Recommendation Report for Approval of Reserved Matters Following Outline Approval

REF NO:	P/24/20/RES
LOCATION:	Land North of Sefter Road & 80 Rose Green Road Pagham
PROPOSAL:	Approval of Reserved Matters pursuant to condition 1 (Reserved Matters details), condition 6 (Design Code Masterplan) and condition 7 (landscaping and layout details) following the approval of Outline planning permission P/134/16/OUT for the erection of 280 dwellings, (including affordable homes), replacement scout hut & Ambulance Community Response Post Facility; provision of a primary vehicular access from Sefter Road; demolition of No. 80 Rose Green Road & creation of a pedestrian & emergency only access; provision of Public Open Spaces including associated children's play areas, landscaping, drainage & earthworks. This application also lies within the parish of Aldwick. This site falls within the Pagham North SD2, CIL Zone 1 (Zero Rated).

Plot No :  
120 - 128 (AS)

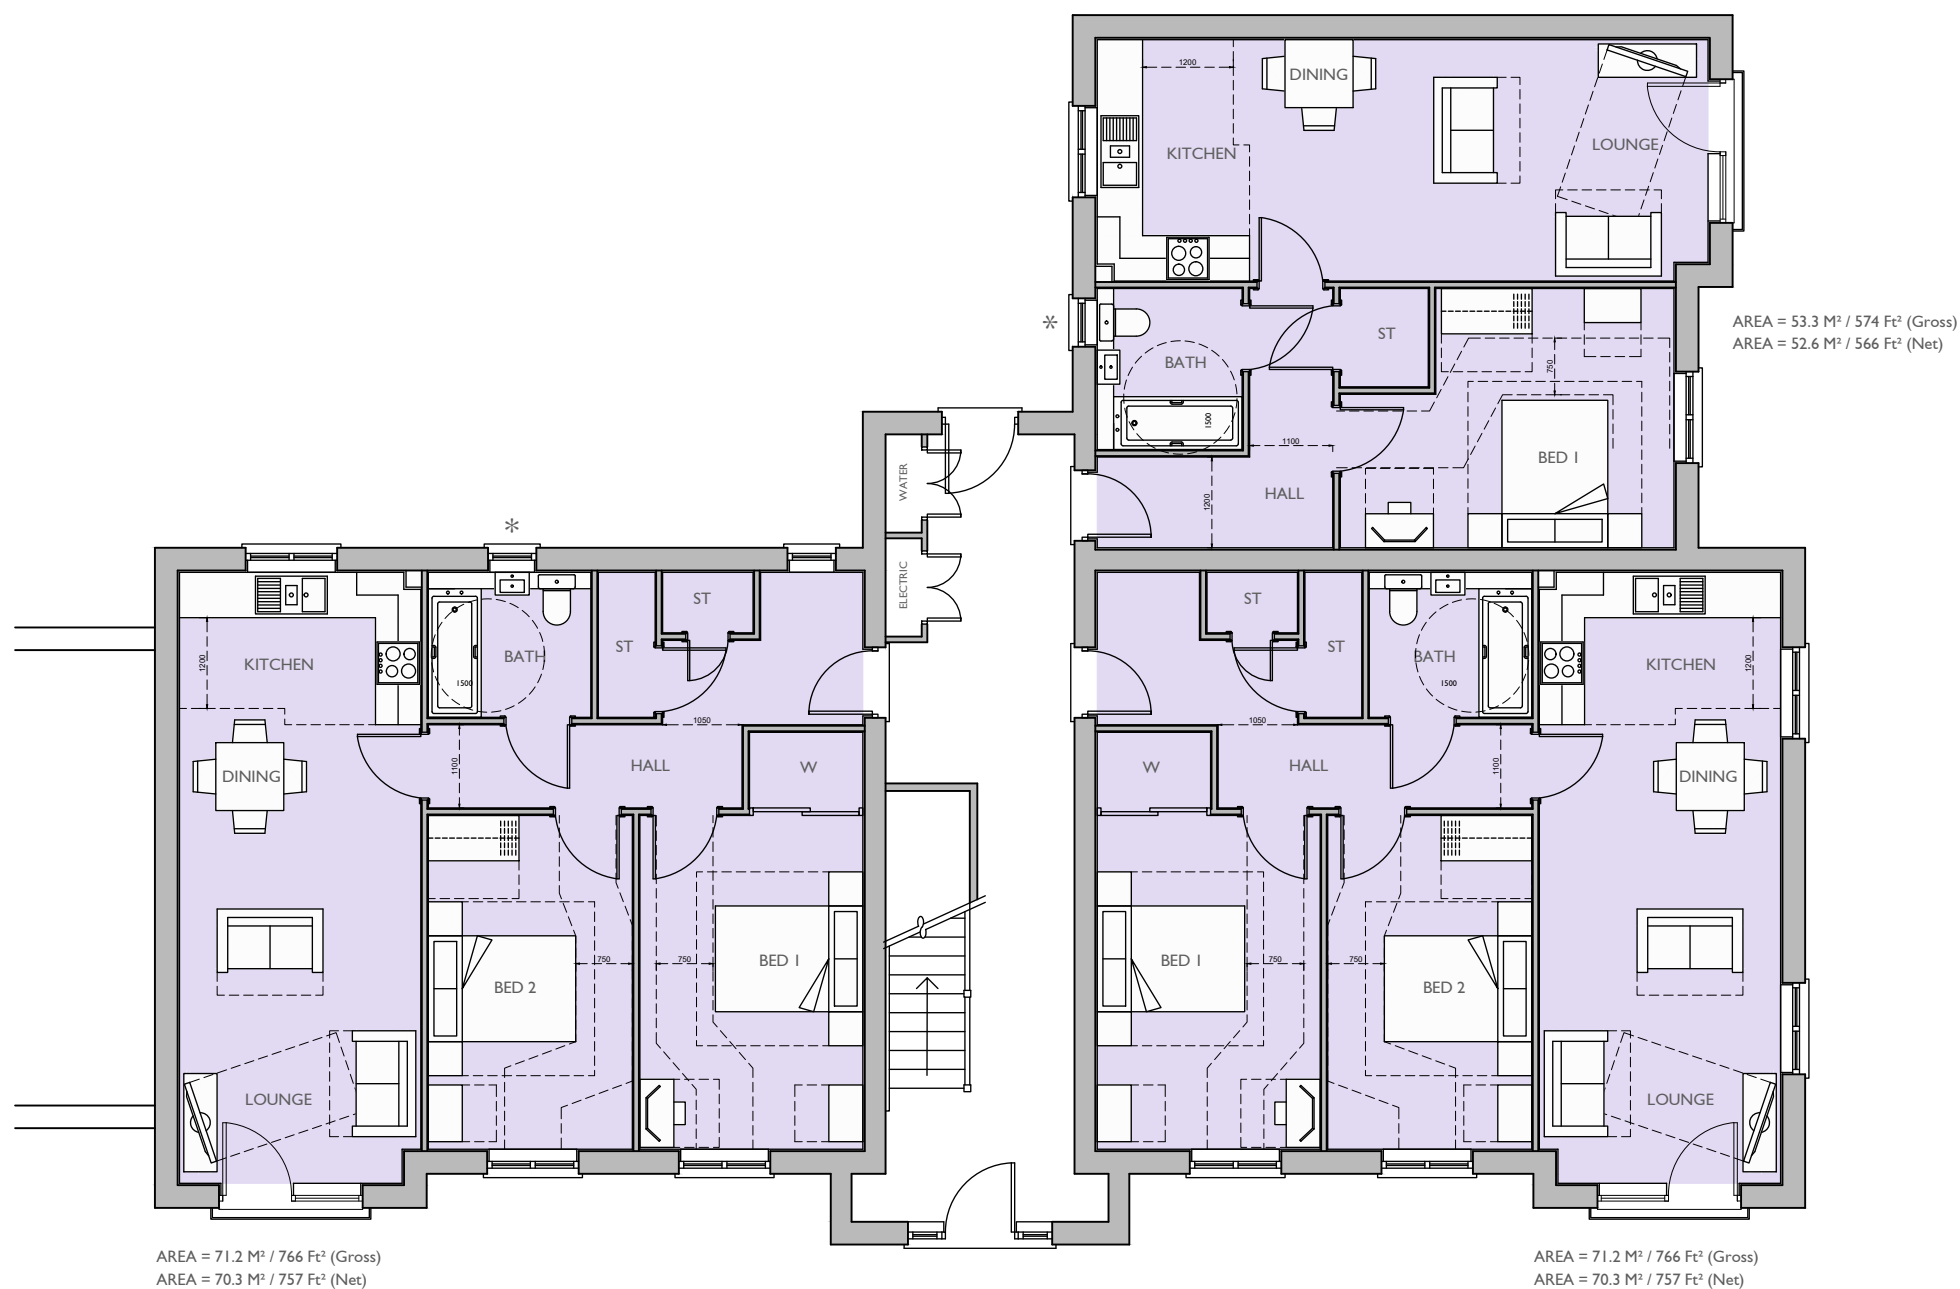
The submitted elevations and street scenes show a high ridgeline and substantial volume for the roof of each of the proposed blocks of flats. These buildings are of a significantly different scale to the proposed two-storey buildings in their immediate locality, as well as the existing single-storey and 1.5 storey dwellings surrounding the site. Thus, the scale of some of the proposed buildings is considered to be inappropriate for their location. In this respect, it is considered that the proposed development does not accord with Policy D DM1 (14) of the Arun Local Plan
